TOWN AND COUNTRY PLANNING ACT 1990

Reference: H13-0847-20 **Date of Decision:** 11th December 2020
Applicant: Mr J Hook
The Anchor Inn
280 Bridge Road
Sutton Bridge
Spalding
PE12 9SH
Location: Rear Of 46 Seas End Road Moulton Seas End Spalding
Description: Erection of 2 detached dwellings

South Holland District Council hereby give notice that this application has been REFUSED for the above proposal for the following reason(s):

REAR ELEVATION - PLOT TWO

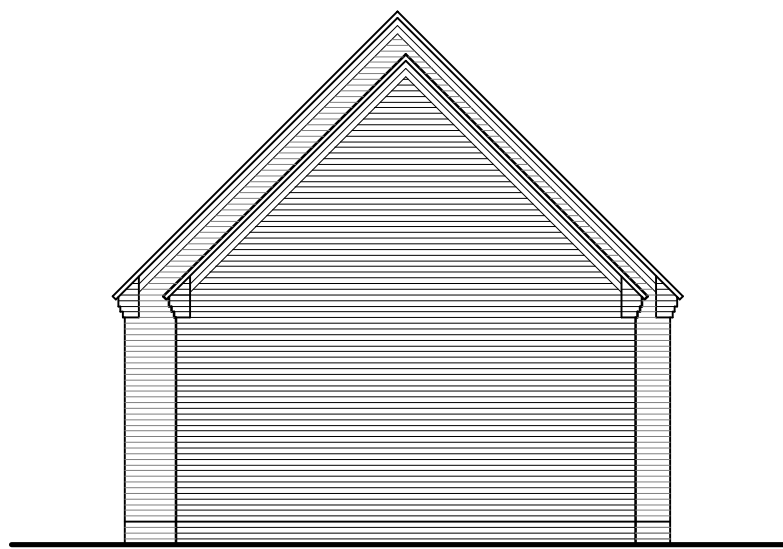
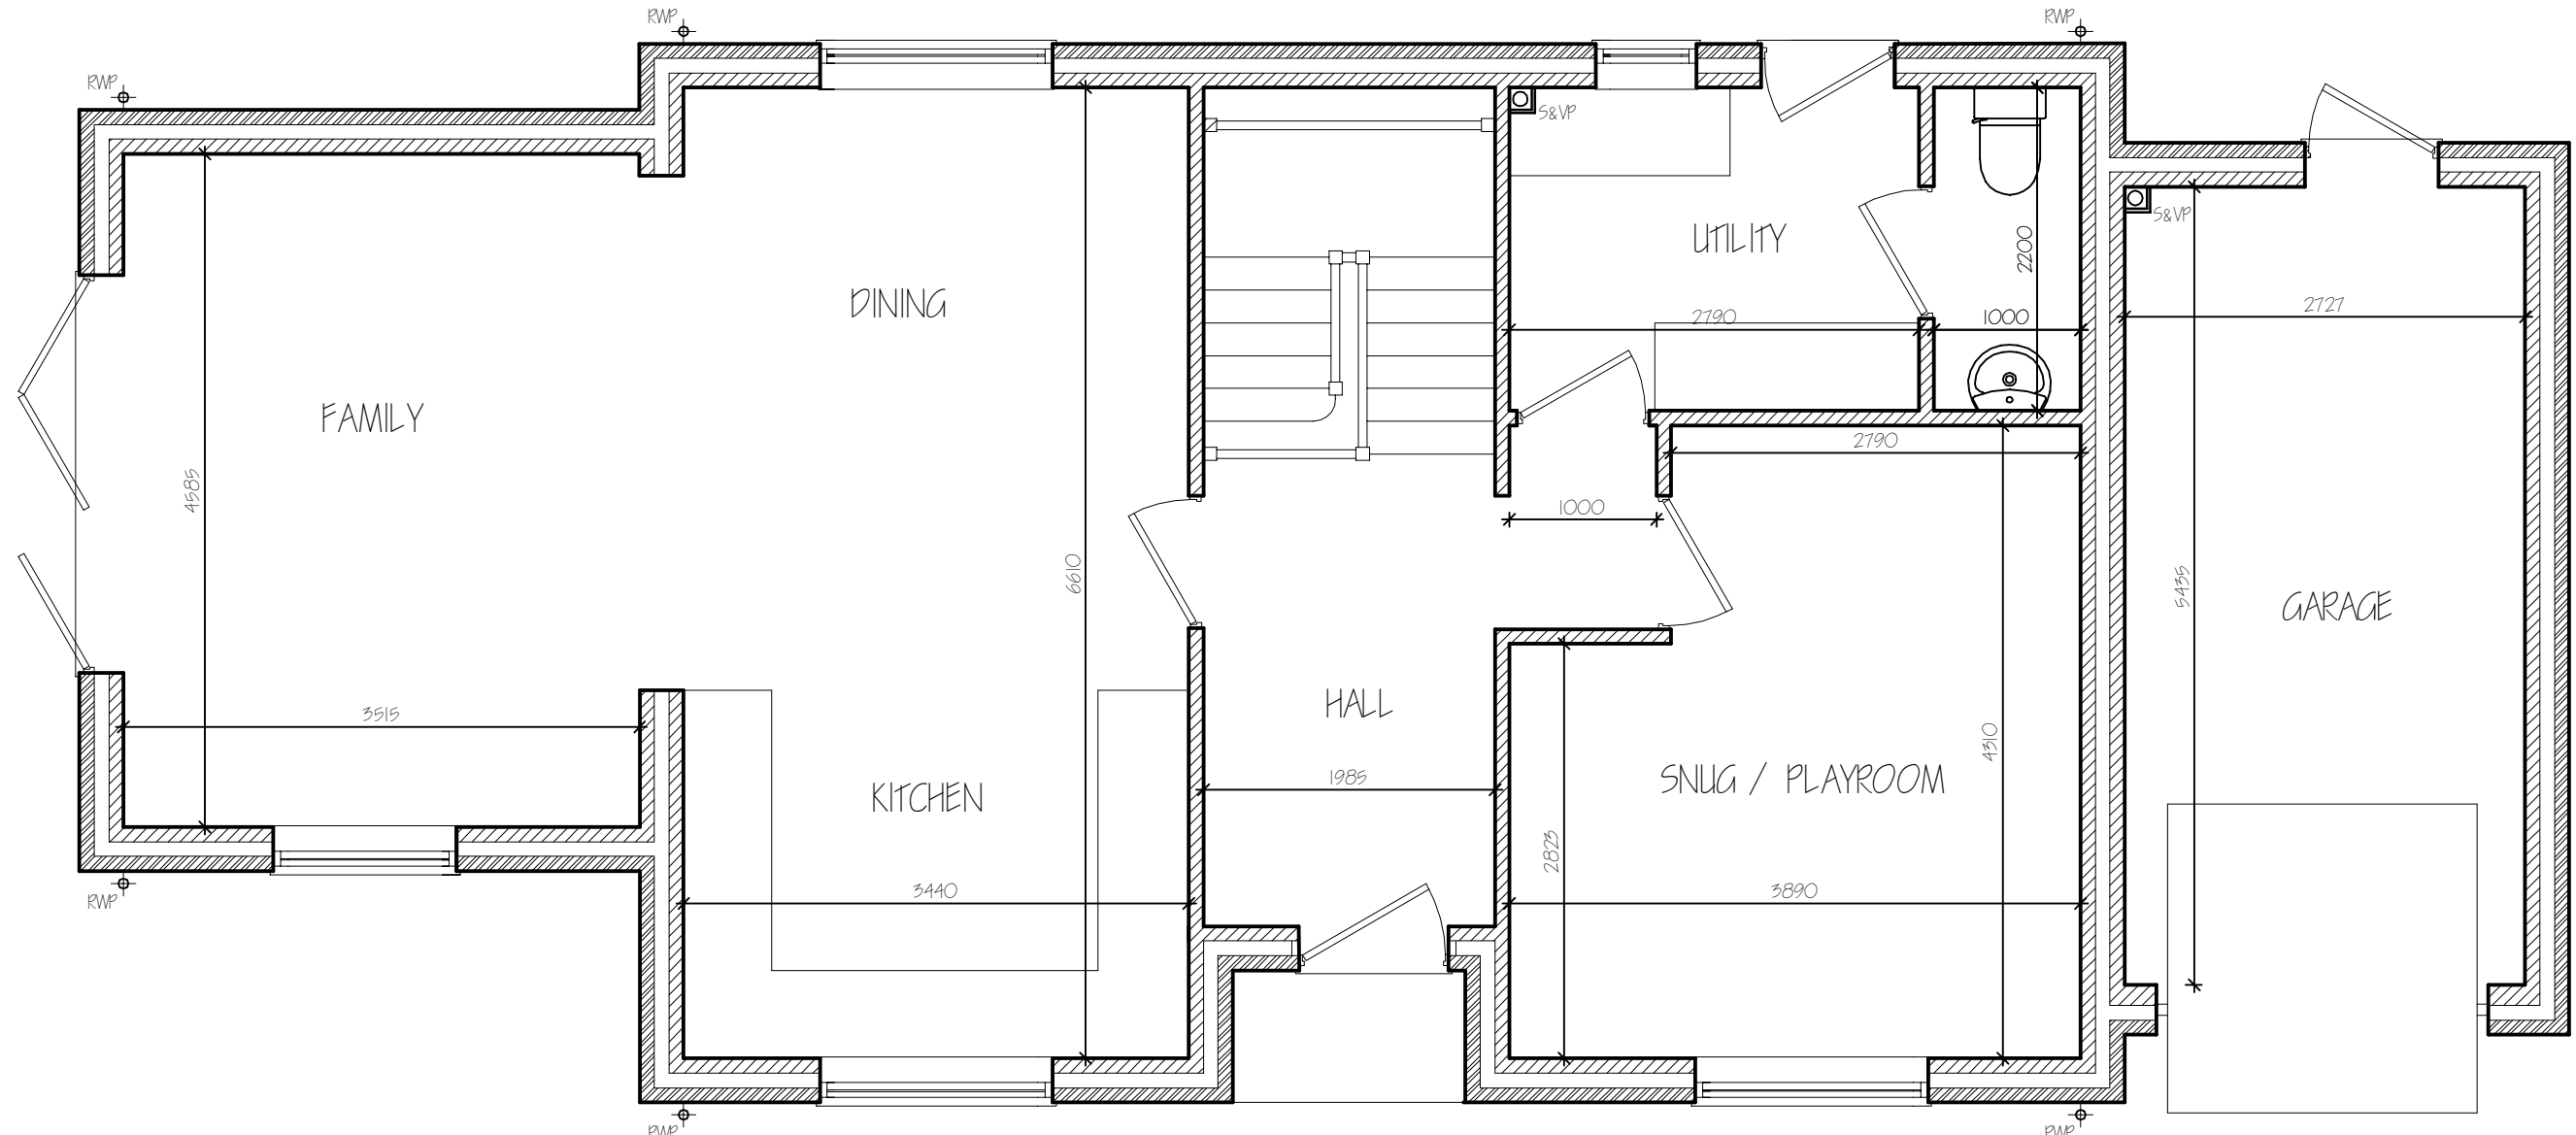
- 2 Taking into account the separation distance between the rear elevation of Plot 2 and the rear elevation of no. 6 Hall Lane, it is considered that there will be a material adverse impact on the outlook of occupants from the rear.
